**IMMINGHAM EASTERN RO-RO TERMINAL DEVELOPMENT CONSENT ORDER APPLICATION**

**PINS REFERENCE TR030007**

**DFDS' ANSWERS TO THE EXAMINING AUTHORITY'S FIRST WRITTEN QUESTIONS**

IMMINGHAM OUTER HARBOUR  
EBB APPROACH  
NOT TO BE USED FOR NAVIGATION

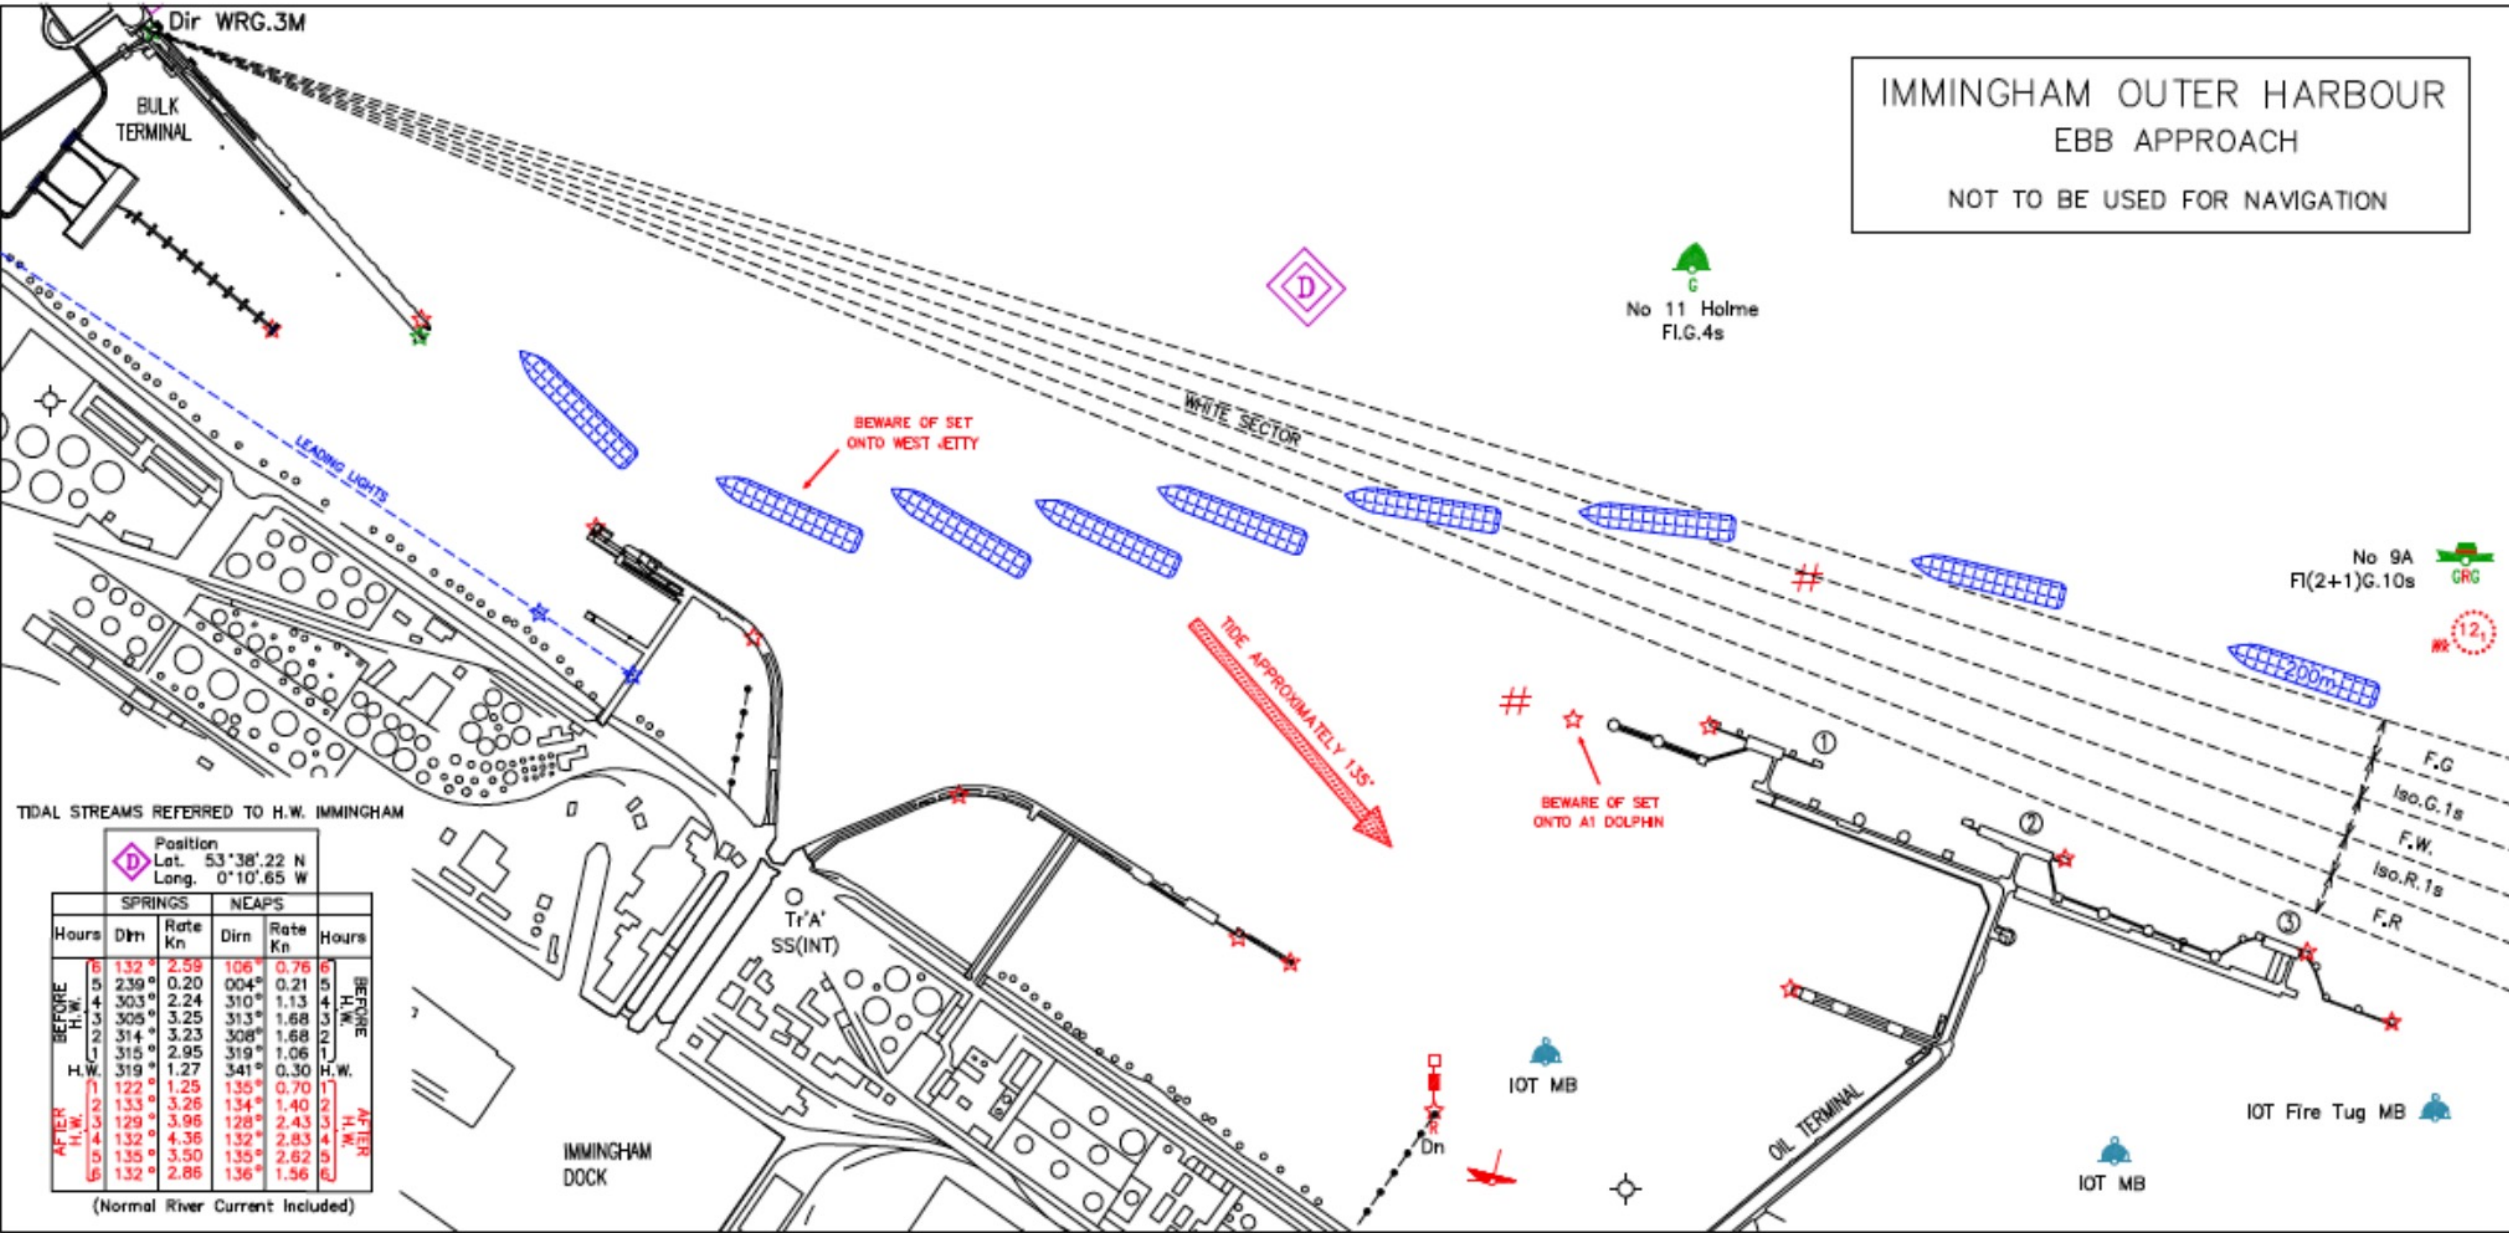
NS.1.21	DFDS	<p><b>Direction of current</b>  Explain the implications of the contention that the current direction north of the Proposed Development is different to that modelled in the navigation simulations presented by the Applicant.</p>	<p>DFDS has had concerns about the tide around the IOT and bellmouth areas for some time and is reflected in our numerous emails and letters in which we spell out our concerns dating back more than 12 months. The daily experience of our masters and the content of numerous publications by the Harbour Authority (and apparently conceded by the Applicant's expert Mr Parr at ISH2) demonstrate that the tide does not, nor ever has, run parallel to the IOT nor parallel to the east and west jetties in the bellmouth area. We cannot, and never would seek to comment about the tidal flow in the vicinity of the proposed development as we, nor any mariner has experience in manoeuvring in this area but the fact that the tide is incorrect around the IOT and bellmouth gives us concerns about the validity of the tide in all areas in the simulated model. Most importantly of all it means the task of manoeuvring around the IOT to get into a position to manoeuvre safely onto the proposed terminal is made significantly easier in the simulations, since if the current is parallel to the berth then it is much easier to dock or leave the berth, but if it is at an angle, even a small one of 20 degrees or so, the manoeuvre is more difficult as the current is pulling the vessel away from the desired path. See also answer to NS.1.23 below.</p>

NS.1.23	DFDS	<p><b>Admiralty Chart data on current direction</b></p> <p>With regard to paragraph 3.23 of DFDS' Relevant Representation [RR-008], submit a copy of the cited Admiralty Chart data and provide a commentary on how the direction of tidal current in the vicinity of the western end of the IOT jetty and pontoons might affect the safety of berthing manoeuvres for the Proposed Development and the IOT's berths. (If not already fully answered in written submission following ISH2)</p>	<p>DFDS ordered the Admiralty Chart and it has just been received. It is of A0 size and so difficult to scan or photograph. It will be sent to the case team by post and should arrive by Deadline 3.</p> <p>As will be able to be seen from the chart and the appended ABP Humber Estuary Services published document (see <b>Appendix 1</b> of this document) the tide runs at an angle to the line of the IOT. The IOT berth is oriented at 292°/112° whereas the tide runs at 315°/135°; the effect of this is that vessels are pushed strongly off the berth on a flood tide and strongly onto the berth on an ebb tide. The ebb tide is stronger than the flood tide due to the fact that the Humber Estuary drains over 25% of Great Britain's fresh water.</p> <p>The effect of this is that in the simulations carried out by Applicant the vessels commence their manoeuvre north of the IOT and need to navigate around the end of the berth and into a good position prior to commencing their 'reverse parking' manoeuvre. As the tide in the simulations is, by admission of their own simulation consultants at the hearing, wrong in the area north of the IOT the simulations fail to recreate the complexity of achieving the first manoeuvre. In doing so they give an unduly favourable impression of the complexity of the manoeuvre and the challenges that vessels will face in safely navigating to and from the proposed development.</p>
